**Transport
for NSW**

Exhibition of the Narrabri Gas Project – Multi-Agency Review

Thank you for your letter seeking Transport for NSW (TfNSW) feedback with regards to the exhibition of Narrabri Gas Project Environmental Impact Study (EIS). Please accept this letter as a joint TfNSW and RMS response. A number of points have been raised that should be noted and addressed, as outlined below.

**Figure 4-2 Newell Highway 36.6 metre A-double road train route**

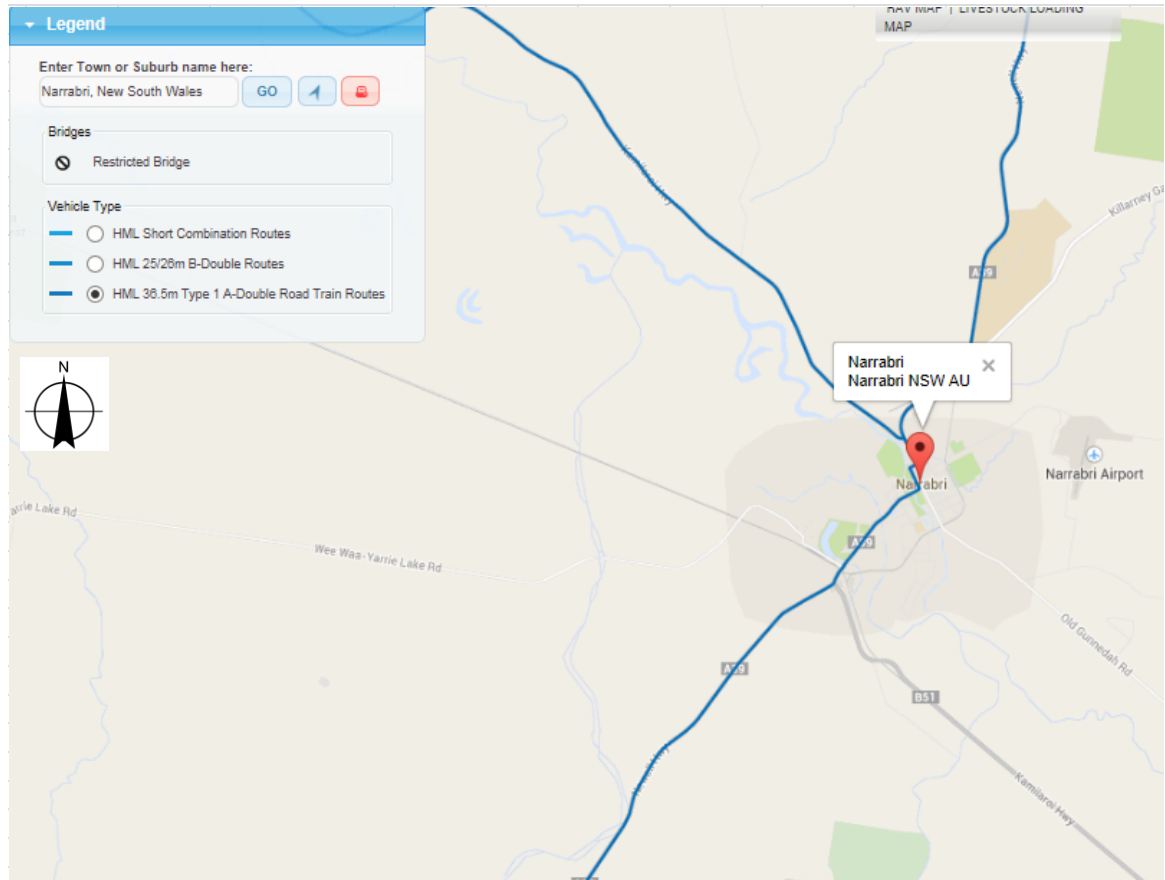
- There is no access for triple road trains in this region. There is access on the Newell in this region for modular B-triples but not for 36.5m B-triples or AB triples.
- The Secretary's Environmental Assessment Requirements (SEARs) requires a clear indication of construction traffic in terms of vehicle type, the general use of 'standard truck sizes' will require further clarity.
- The haulage route from the Port of Newcastle needs to be identified, as the Newell Highway does not provide direct access to Newcastle.
- Clarification is sought as to why both diesel fuel and miscellaneous minor deliveries are being included as part of oversize movements (refer to Tables 5-3 & 5-4 Haulage Movements). The proponent should confirm that all items listed in Tables 5-3 & 5-4 are oversized movements.
- The operational traffic movements in section 6 need to be broken down into vehicle types.
